Proposal: Two small extensions and adaptations within the current curtilage of the property. Requested meeting with Officer.
Location: Rialto Barn Burcott House Farm Wells Road Wookey Wells
Applicant: Mrs Natalie Lansdown
Application Number: 2023/0886/L1PA

Reference: 2023/0886/L1PA
Planning Area: Somerset East
Site address: Rialto Barn, Burcott House Farm, Wells Road, Wookey, Wells Somerset, BA5 1JU
Description of Proposal: Two small extensions and adaptations within the current curtilage of the property. Requested meeting with Officer.
Applicant: Mrs Natalie Lansdown
Somerset Council Case Officer: Oliver Down
Date: 26.07.2023

Title
Elevations
As Proposed

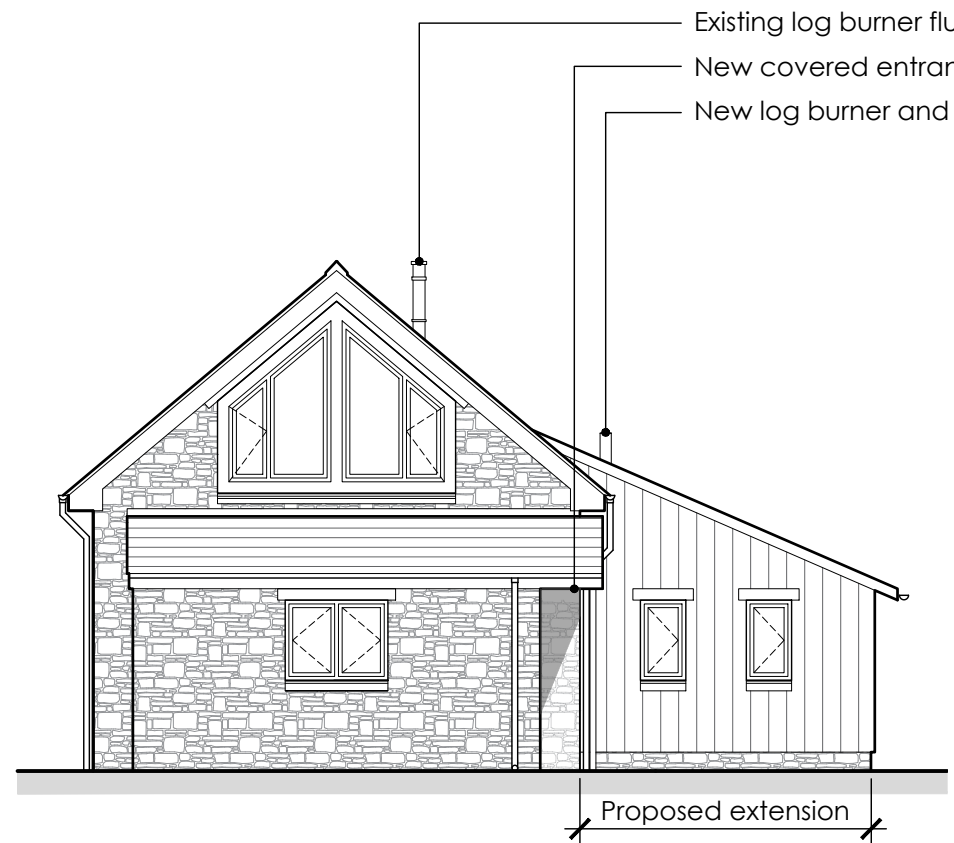
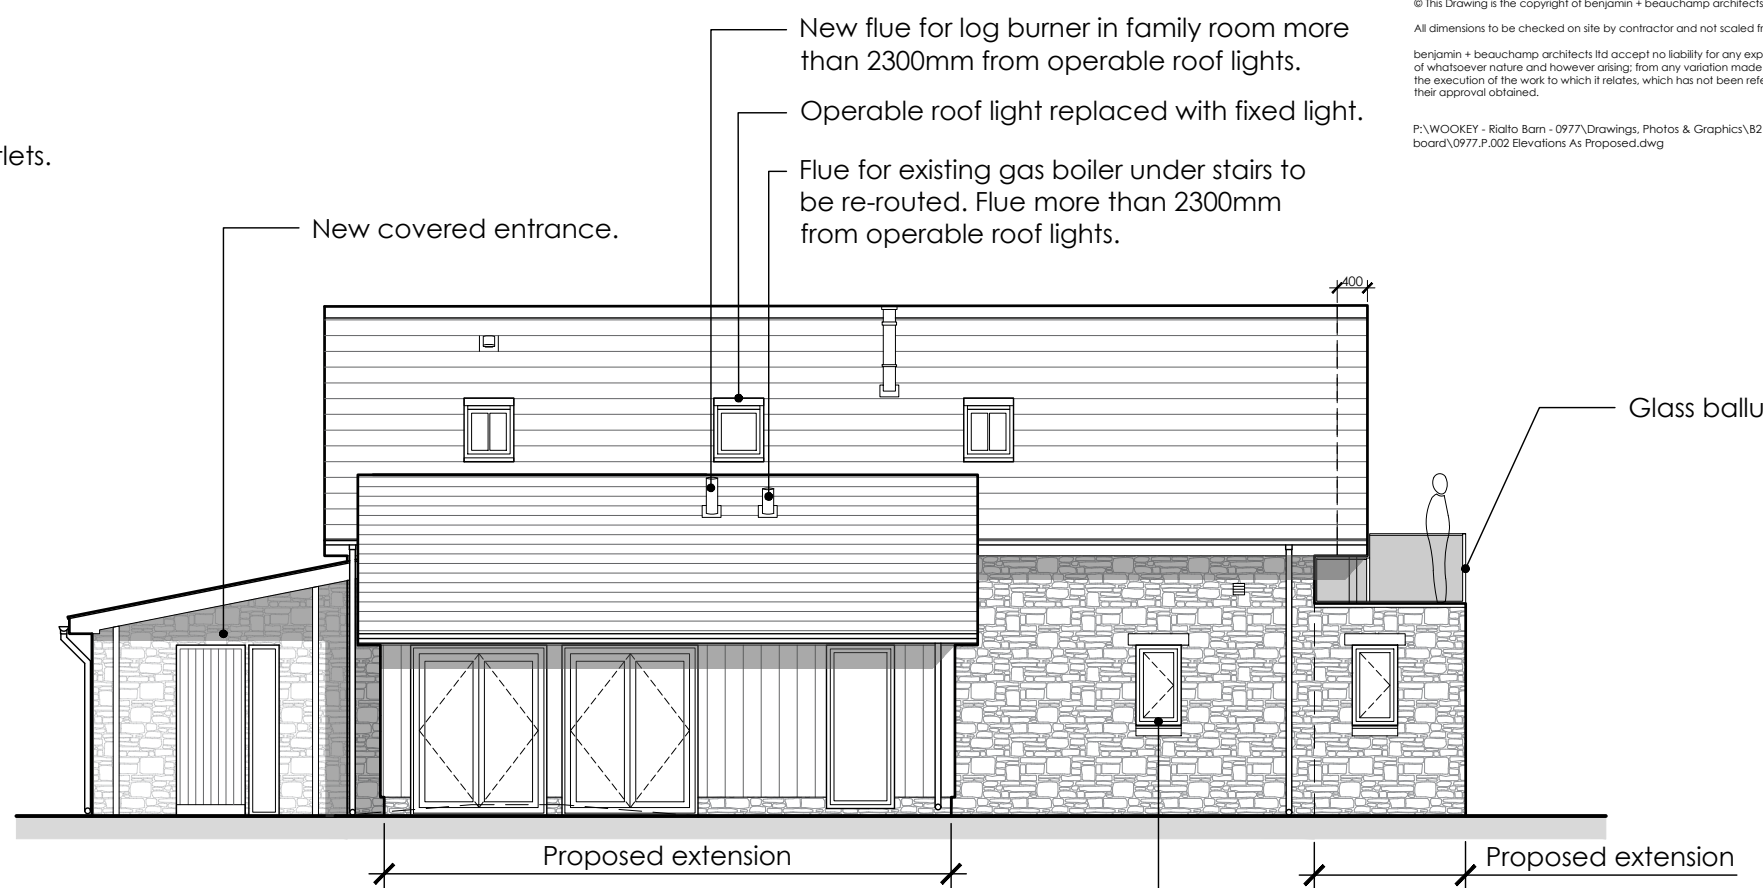
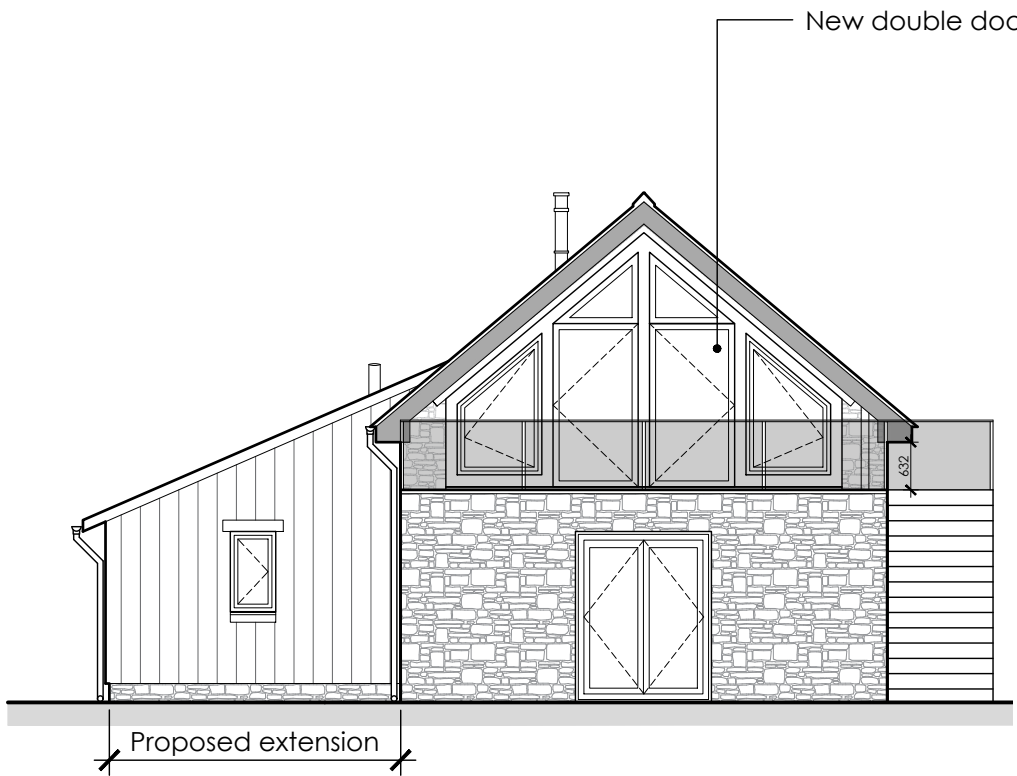
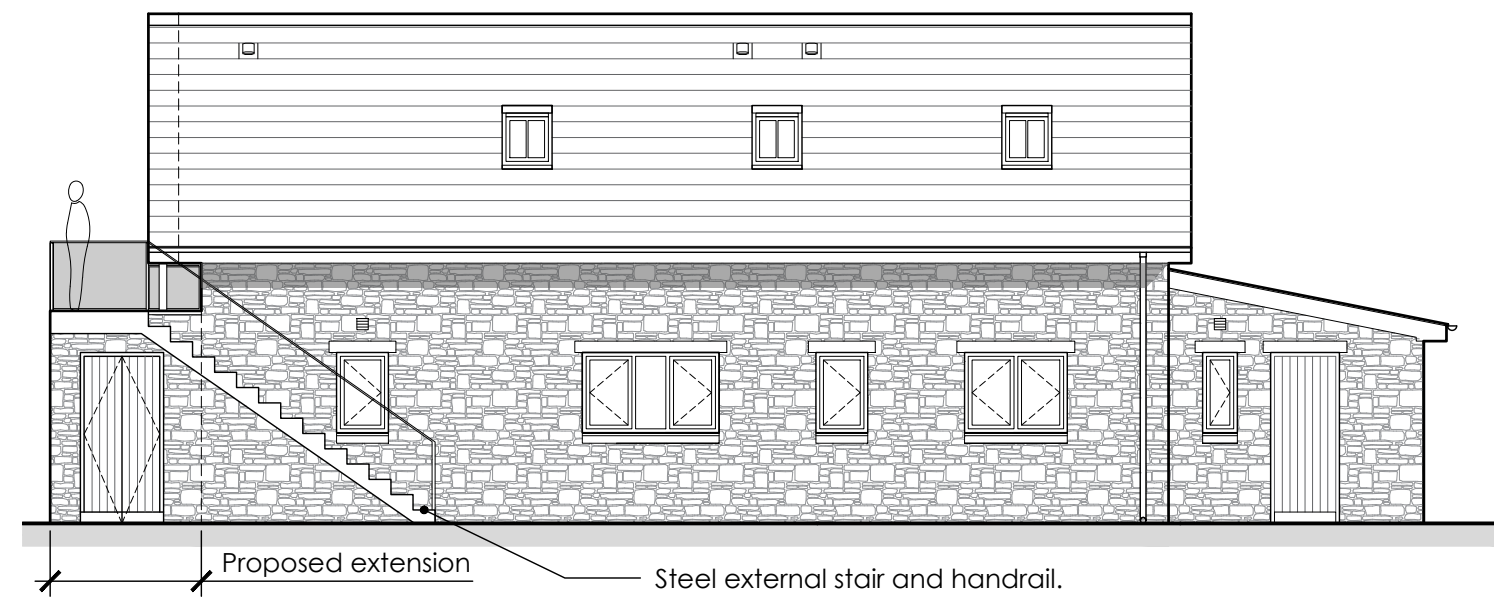
The design needs to use matching materials and designs. The completion of the barn in 2016 and its use of materials needs to be continued. The new doors to bedroom 1 on the ground floor need to be symmetrical to the in line with the centre of the gable.

Upon further reflection with management, the single storey side extension housing a games room and a bedroom would not be deemed as acceptable.

The design of the barn and its original simple form layout would be affected by the addition of a single storey side extension. The side extension would be contrary to DP1 as the local identity and distinctiveness would be lost with the side extension. The barn needs to maintain the clean silhouette and lines of the former agricultural barn and the addition of the games room and bedroom would detract from this characteristic.

The lengthening of the barn from the gable end would be acceptable due to the form of the barn being followed.

Title
Roof Plan
As Proposed

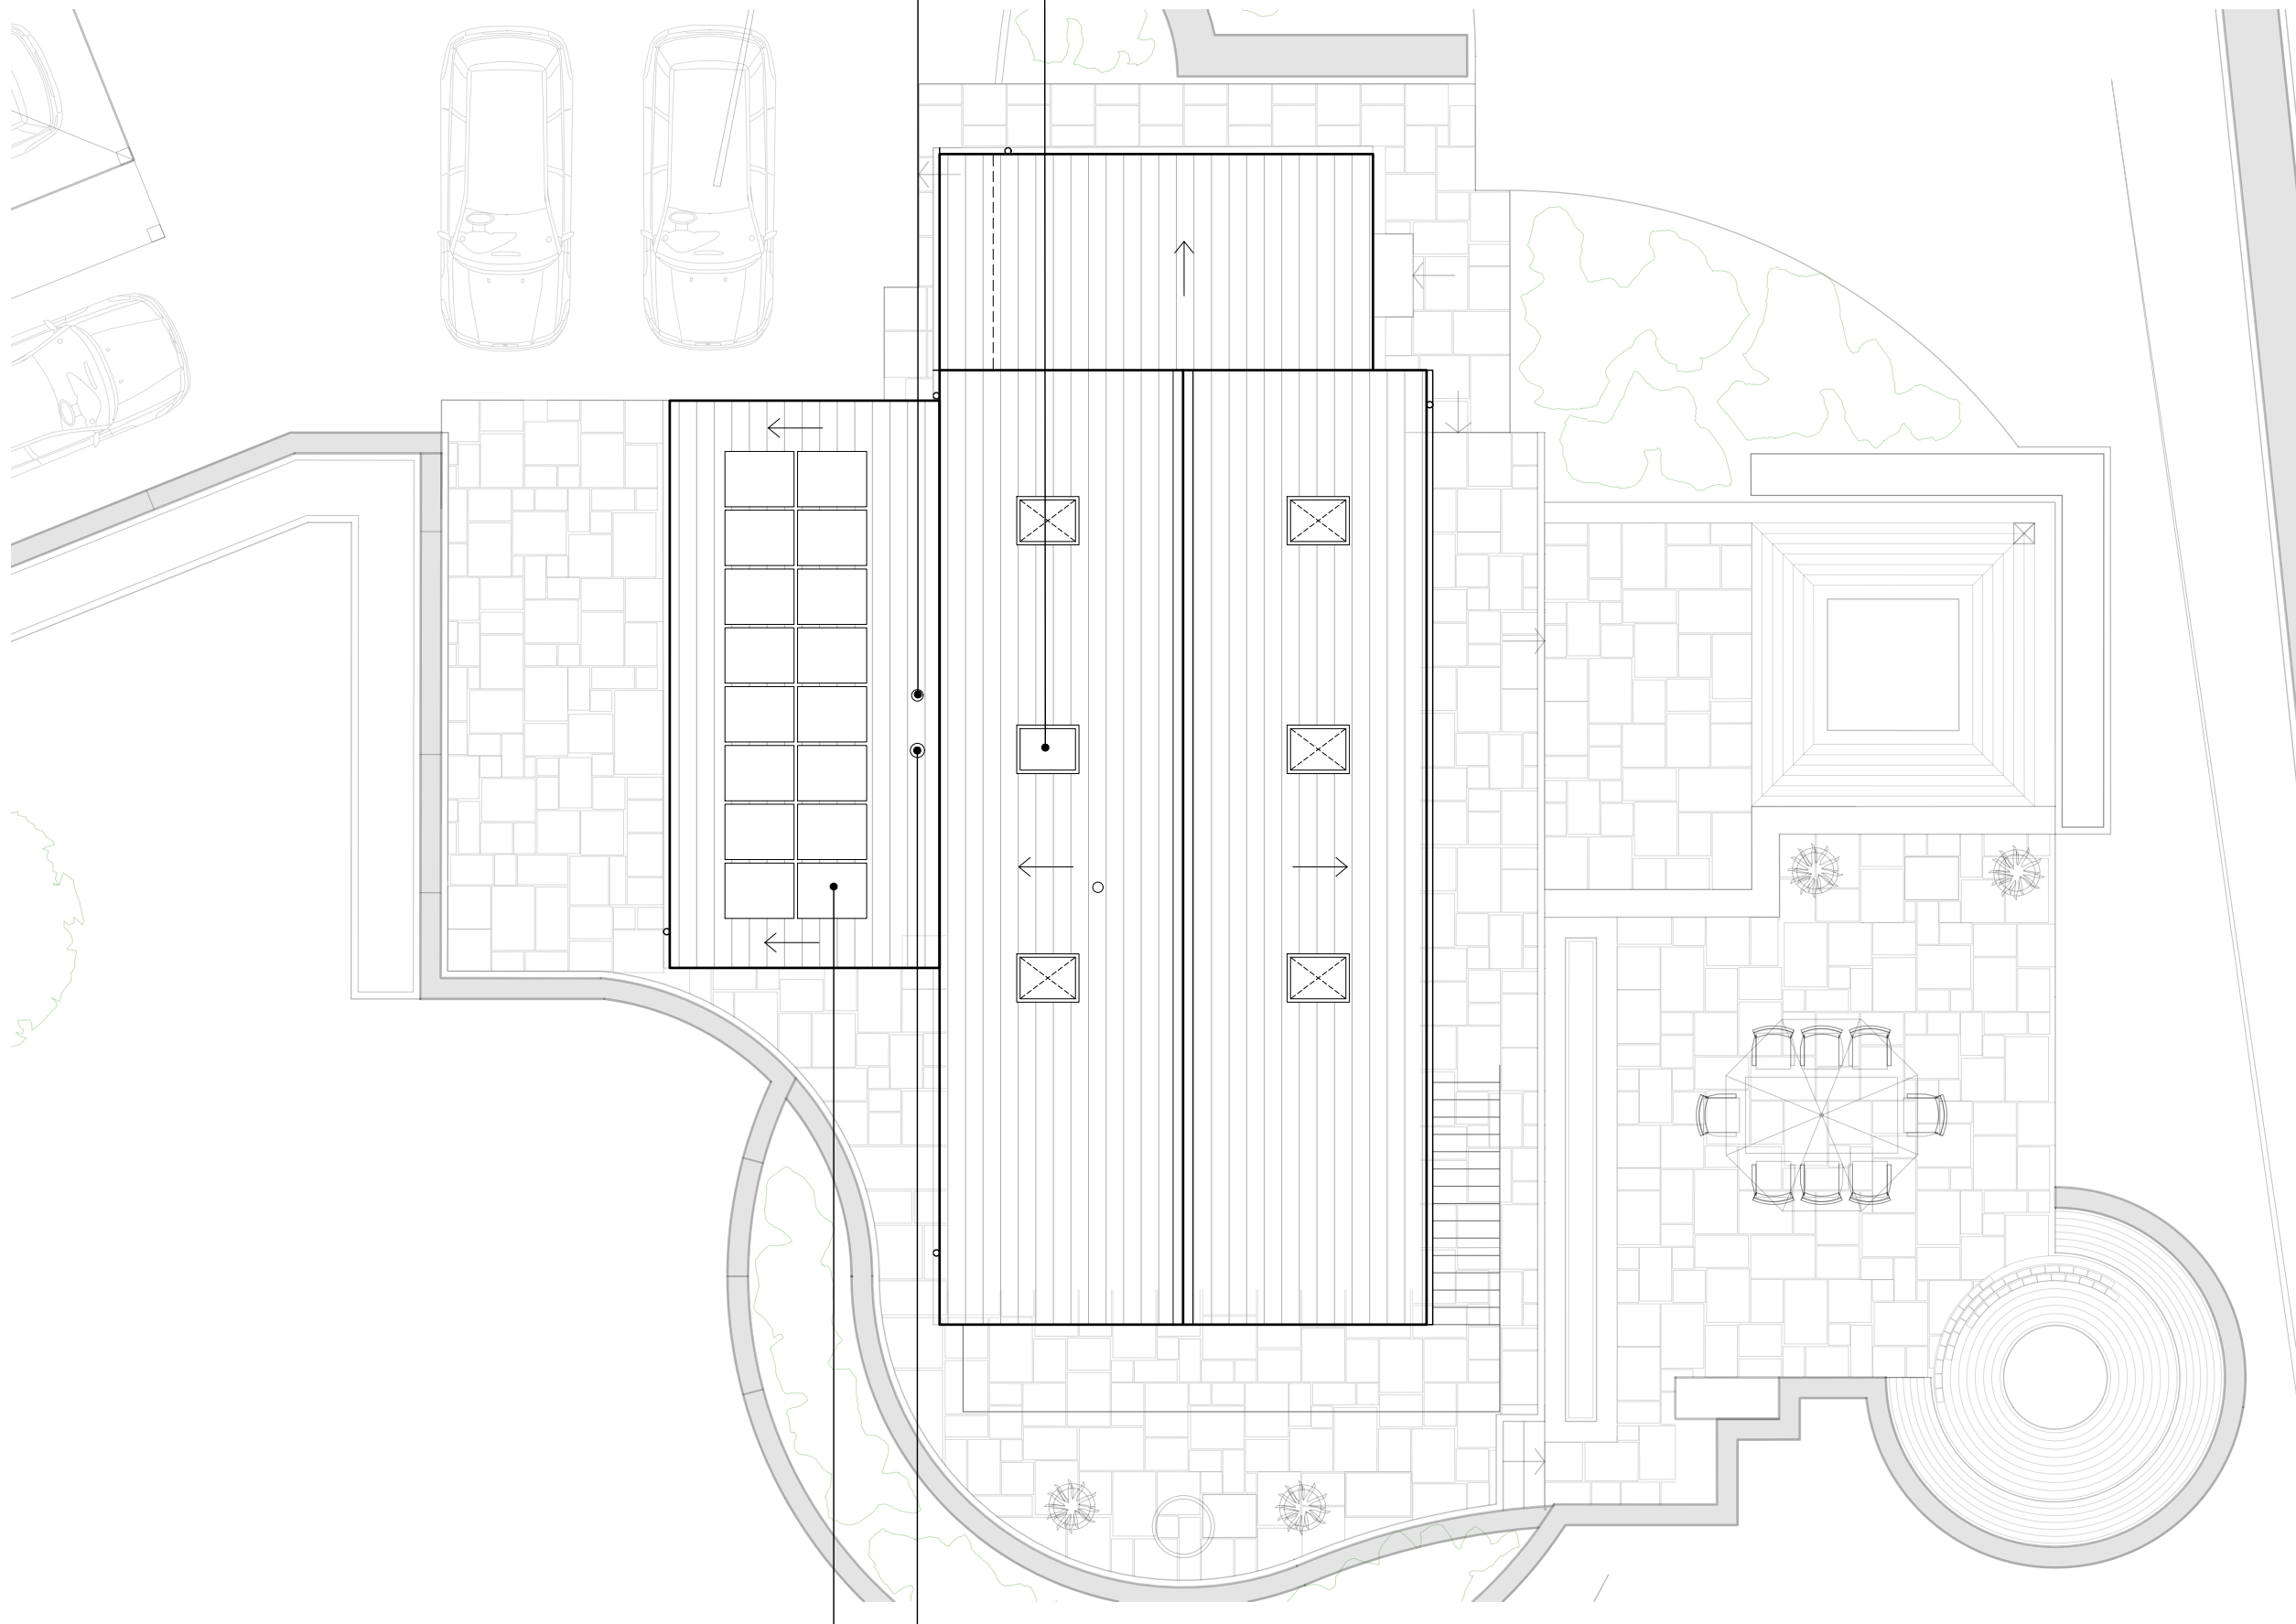
The extension may have scope to add solar panels to the new roof of the side extension. This would need to be confirmed via a qualified specialist
